**RE: Quik Trip Store #7001
521 Unser Blvd NW
Conceptual Grading & Drainage Plans
Engineer's Stamp Date: 05/31/24
Hydrology File: K10D071**

Based upon the information provided in your submittal received 06/04/2024, the Conceptual Grading & Drainage Plans are preliminary approved for action by the Development Facilitation Team (DFT) on Site Plan for Building Permit.

Re: QuikTrip 7001, Albuquerque
Matkin Hoover Job No. 7001.01
Hydrology File No. K10D070

SHEET NUMBER:
C100
05 OF 25

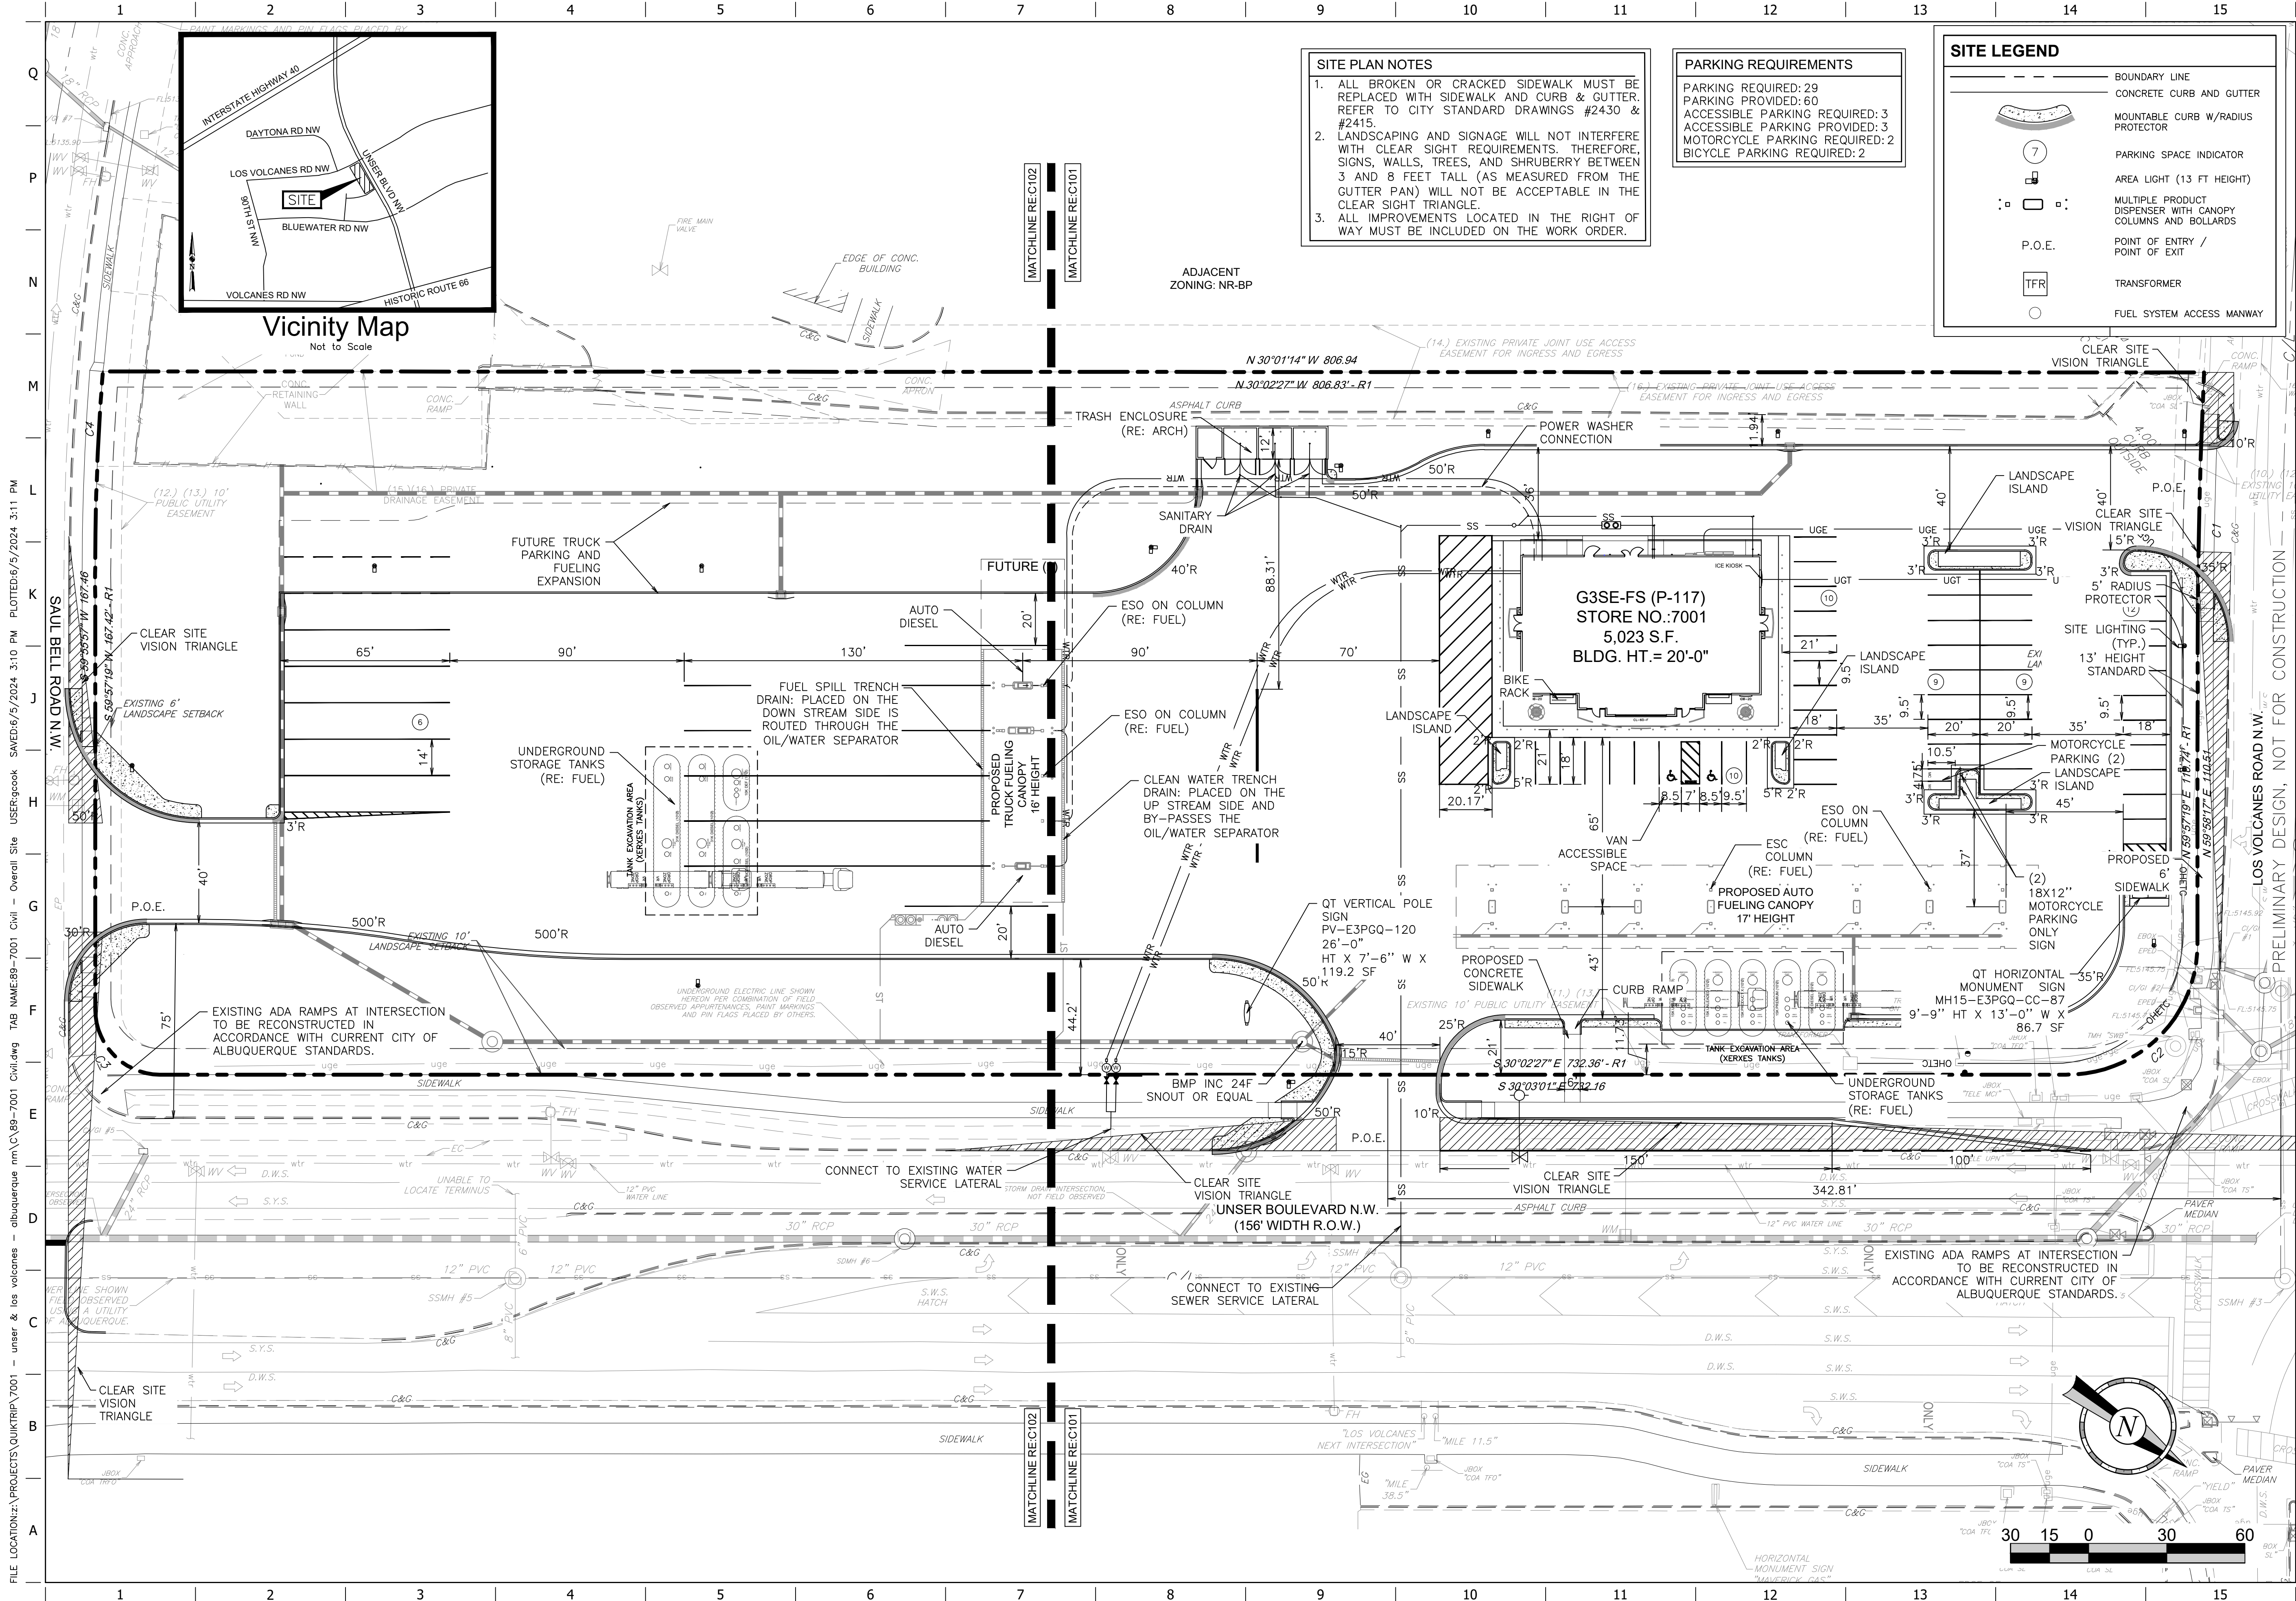
There is an existing inlet at the driveway location. The entrance needs to shift over about 15 feet to ensure that the back of curb radius is tangent at the inlet's transition section.

Inlet changed to single combo curb inlet and moved to appropriate location. Manhole added where existing inlet location is.

SHEET TITLE:
GRADING PLAN NORTH

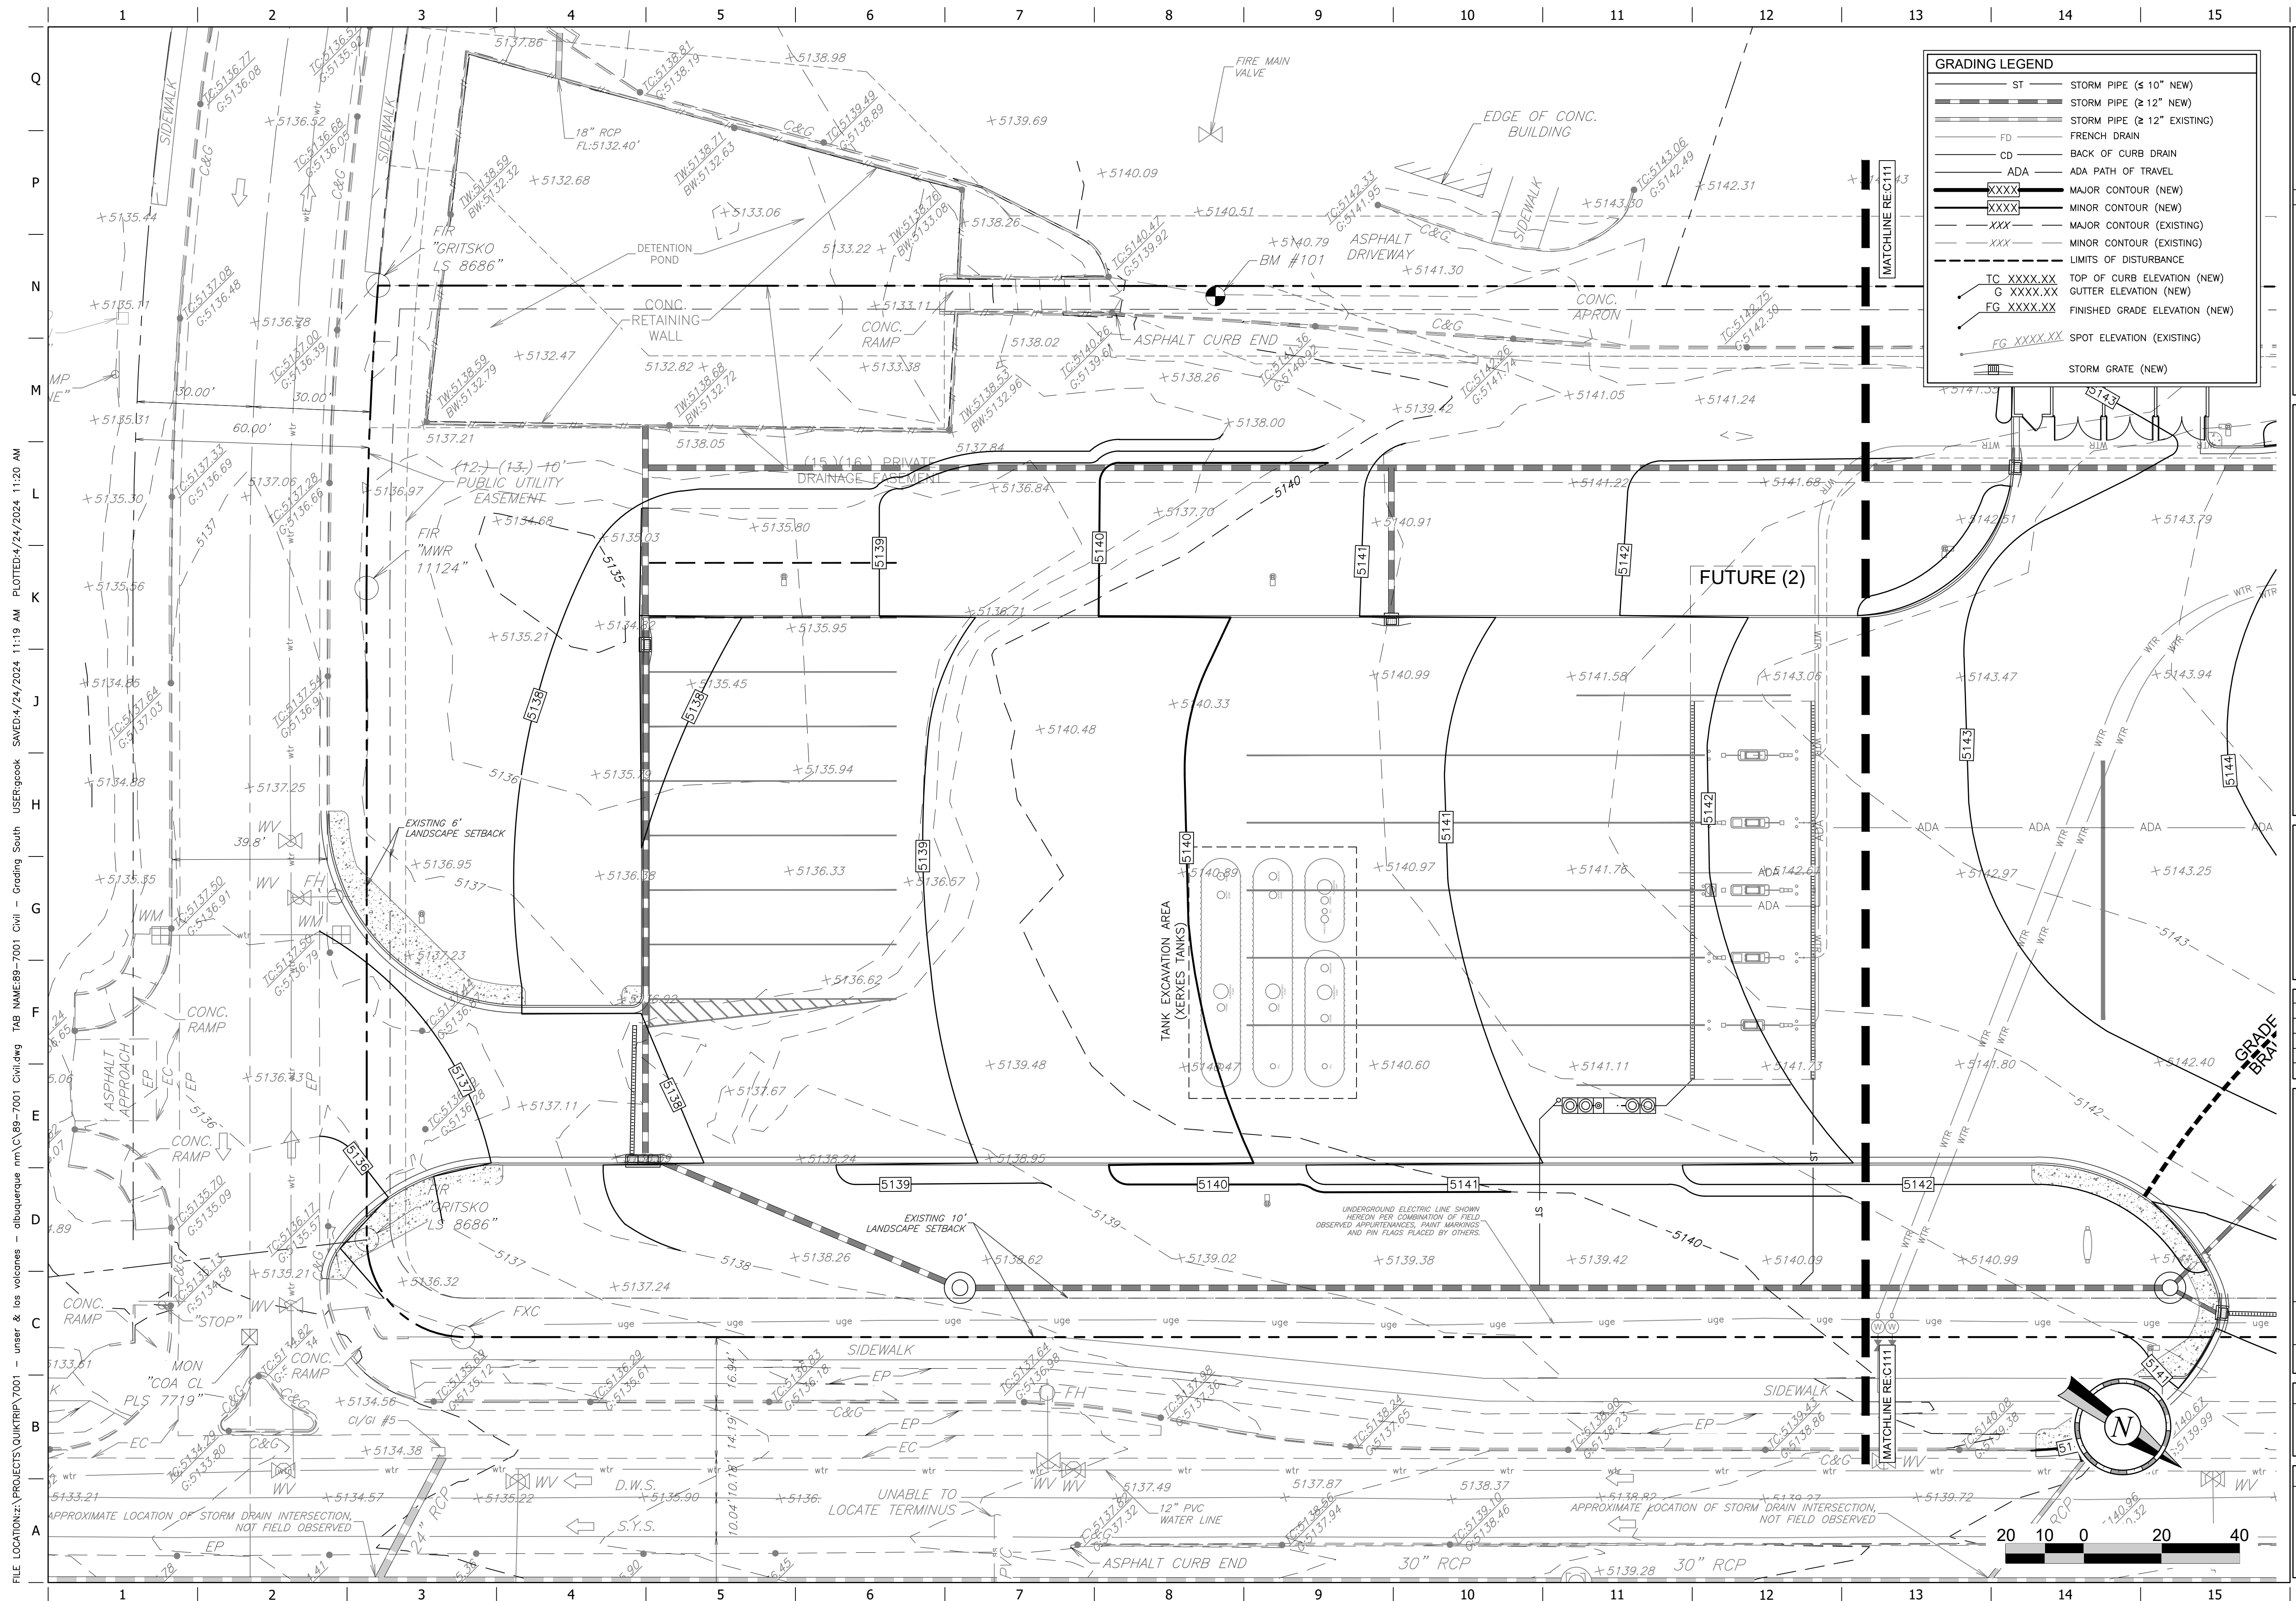
Please number the ponds and include a label on each with the SWQV and elevation, the 100-year volume and elevation, the peak 100-year inflow and outflow, the spillway crest elevation, the spillway flow depth, and the dam top elevation.

All gas stations must drain to an oil/water separator (the Owner's choice) prior to discharge. This is mainly for the area around the pumps, so some previous stations have placed this prior the remainder of the runoff going into the Stormwater quality pond. Since this site appears to be collected in a pipe system, instead of a manhole, this can be an oil/water separator.

Please include the proposed pipe sizes on the Conceptual Grading & Drainage Plans.

BMP Inc. 24F snout added. Callout added to relevant sheets.

Proposed pipe size length and diameter added to all grading sheets.
